Engineers Comments Regarding Surface Water Drainage

Application Reference:	Y/48/25/PL	Reviewer Reference:	ADC/KW/SB/PC
Planning Officer:	Harry Chalk	Date of Review:	13/02/2025
Site Name:	Church Farm House Church Road Yapton BN18 0EP		
Application Description:	Removal of tennis court and construction of 1 No. self-build single storey energy efficient dwelling. This application is a Departure from the Development Plan, may affect the setting of listed buildings, affects the character and appearance of the Church Lane, Yapton Conservation Area and is in CIL Zone 3 and is CIL Liable as a new dwelling.		
Assessment Number:	3 of 3

Appendix A – Soakaway Test Location Plan

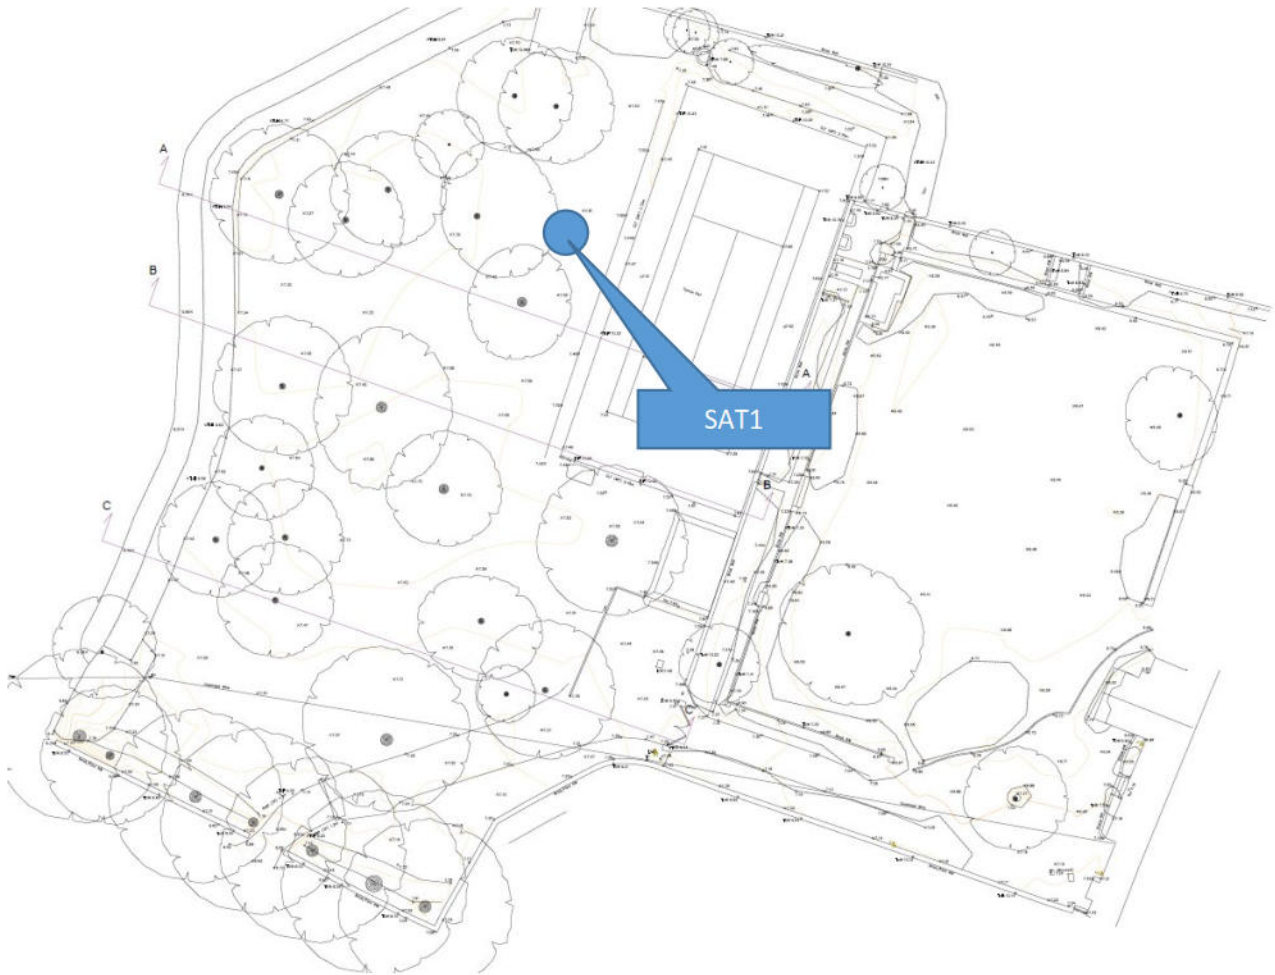
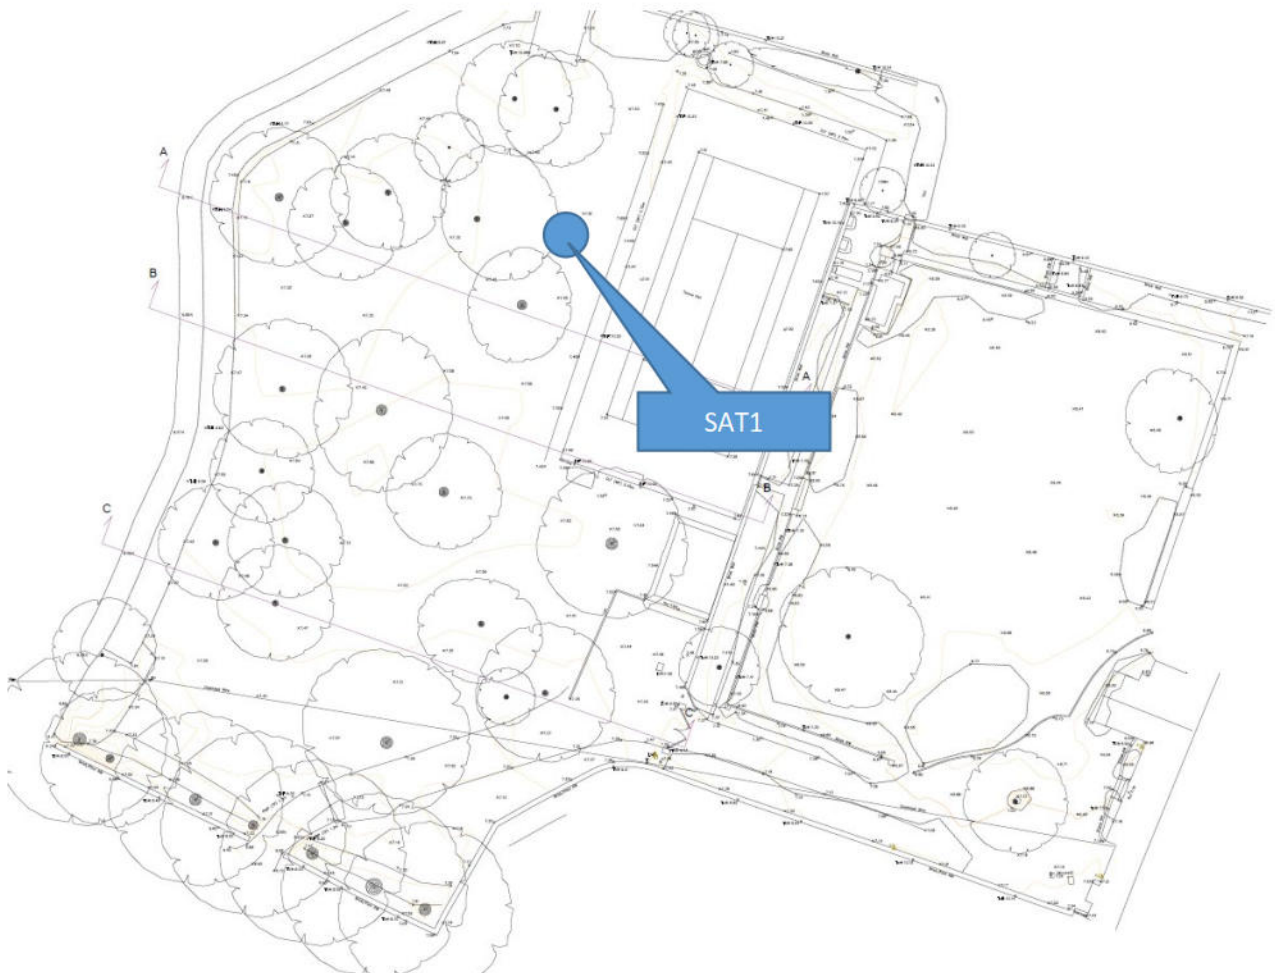
- 0.1. Winter infiltration testing (January 2026) has now been submitted, this demonstrated that infiltration to the ground is both viable and that the SuDS will not increase flood risk on site or to the wider area. The slowest rate evidenced was 1.79×10^{-5} m/s.

- 1.6. As indicated infiltration testing undertaken during winter months has produced a viable rate of 1.79×10^{-5} m/s. This, the slowest rate demonstrated, is considered a good infiltration rate.

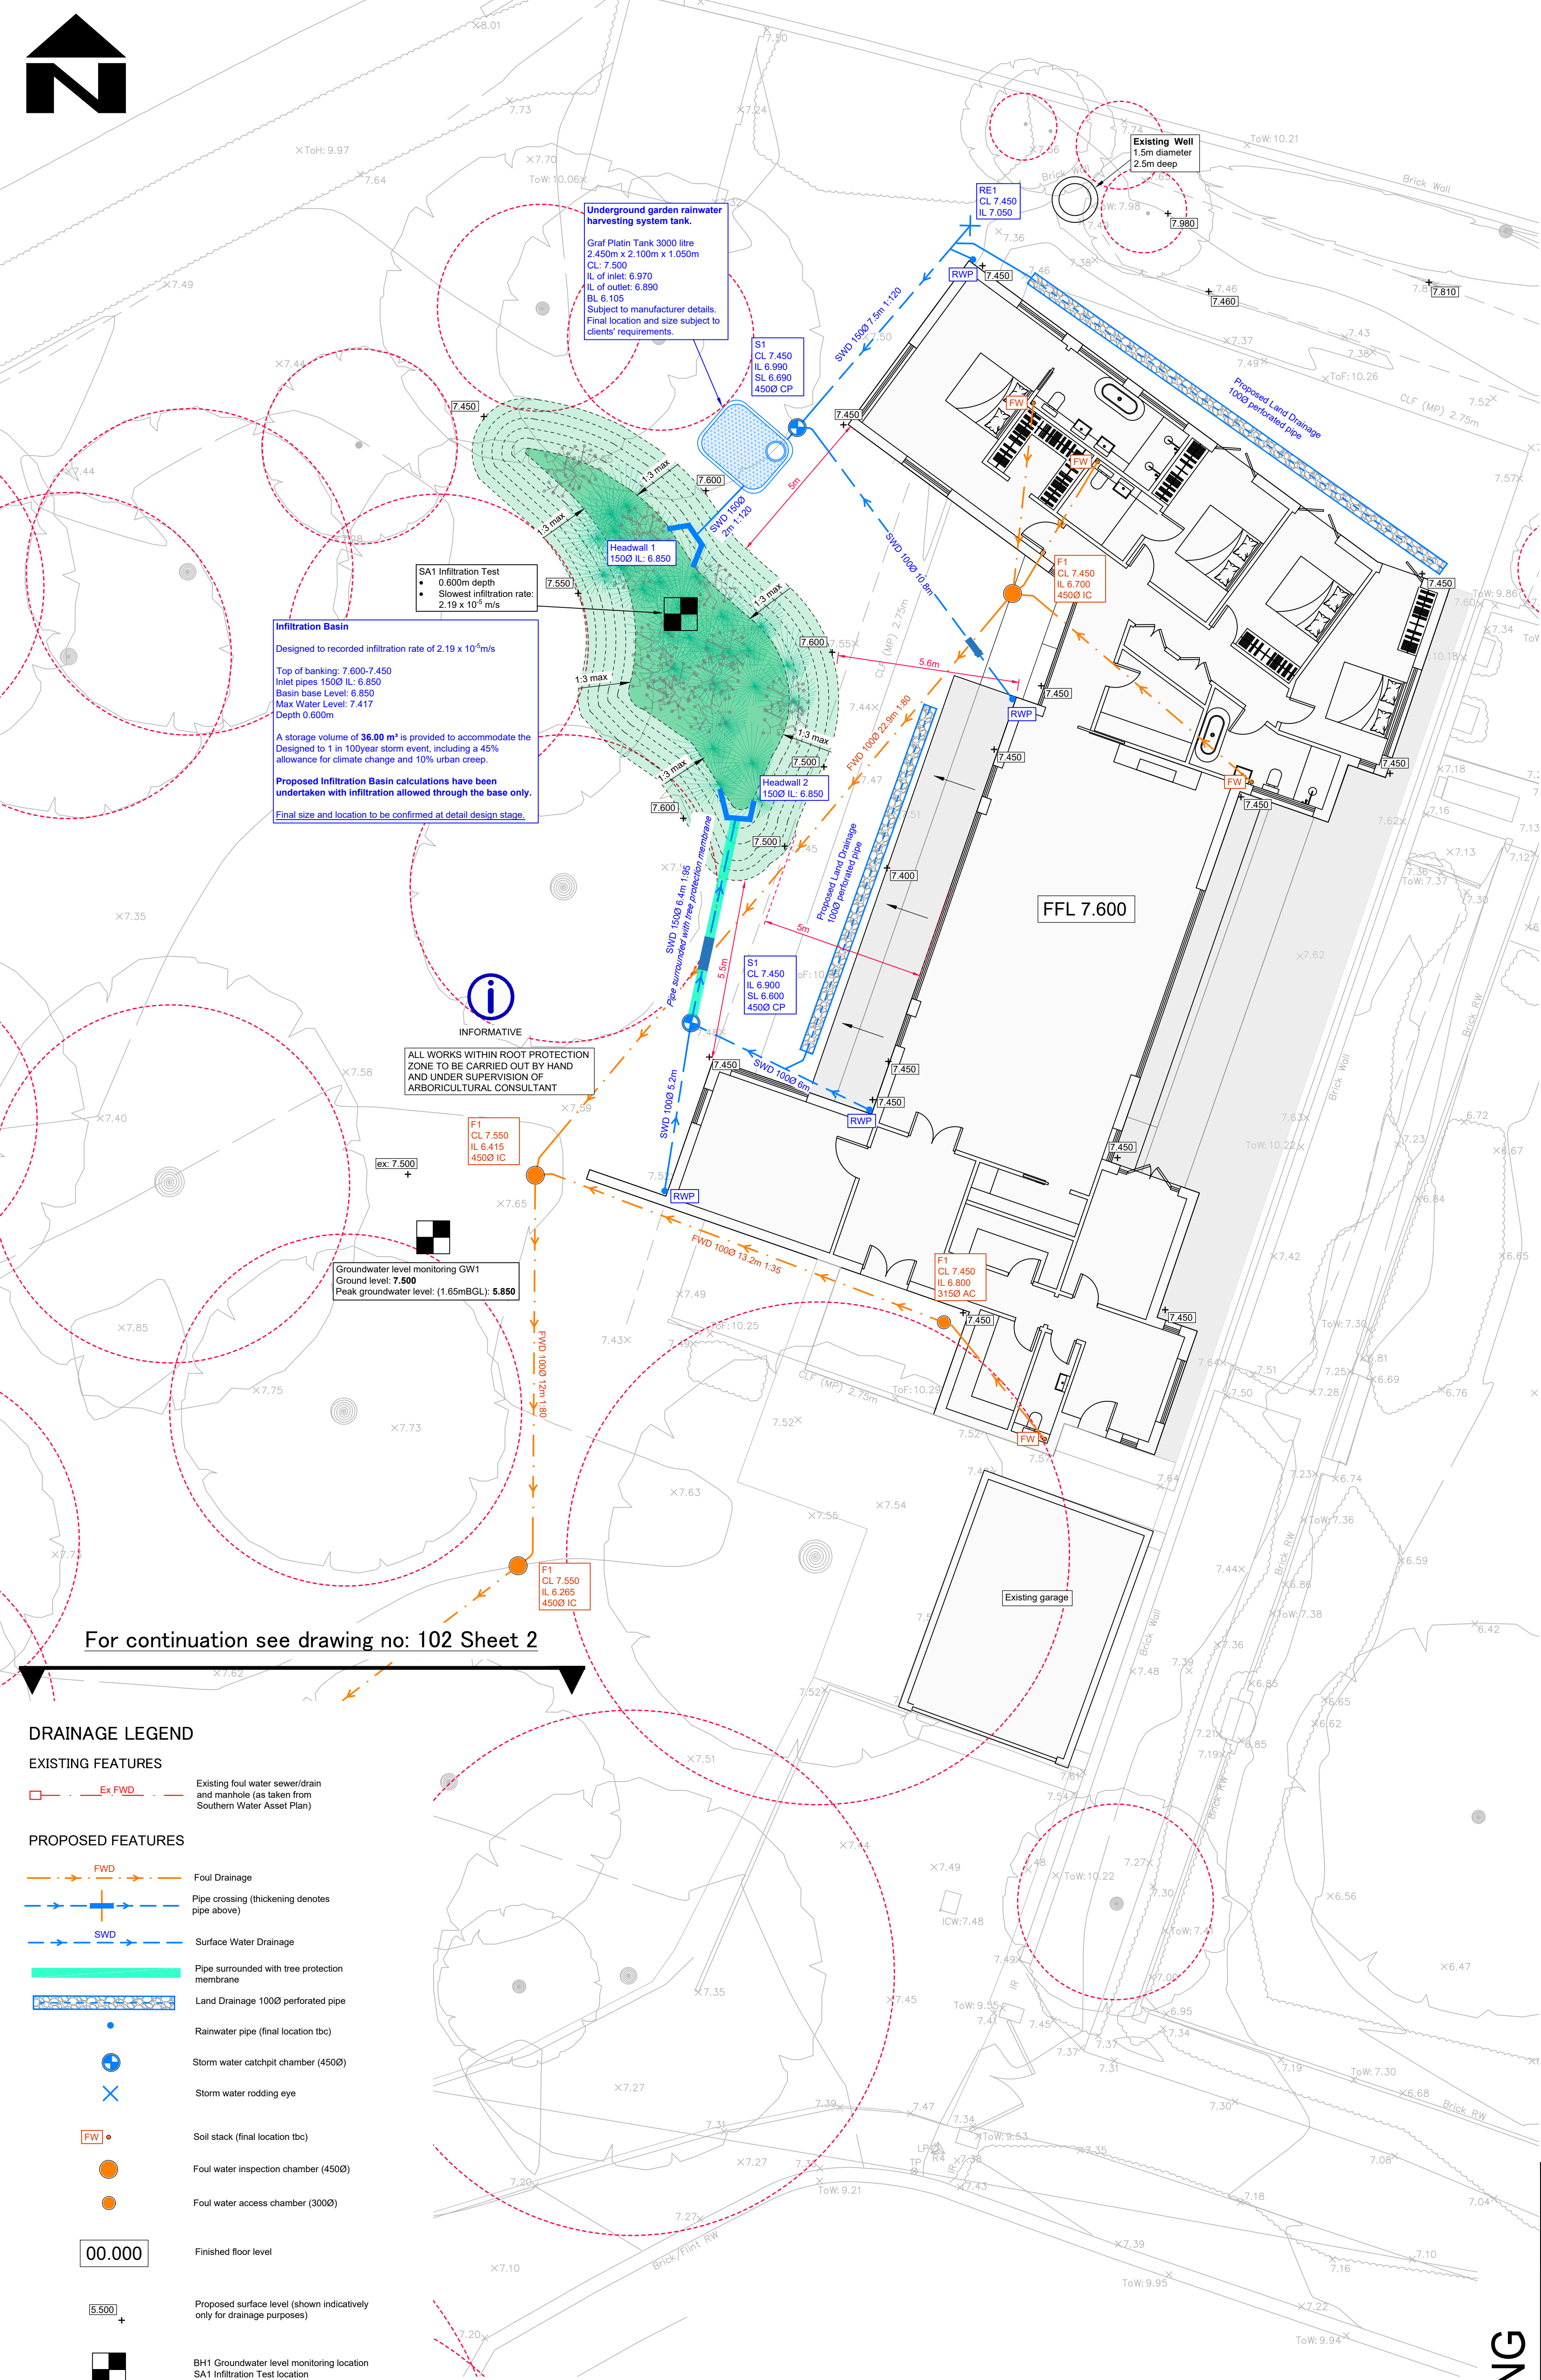
3.1. The FSWDR includes drainage plans and modelling. The simulation for the 1% AEP + 45% event has a maximum water level in the basin of 7.439mAOD. The bank at the northeast extent of the infiltration basin has now been increased in height to 7.500 AOD. As a result of the finished floor level of the dwelling being raised to 7.750 AOD, the cover level and rodding eye have also been increased to 7.600 AOD which is acceptable and an appropriate freeboard is now confirmed. Subject to confirmation of an infiltration rate/storage requirements it is now confirmed that the system would not flood during such an event.
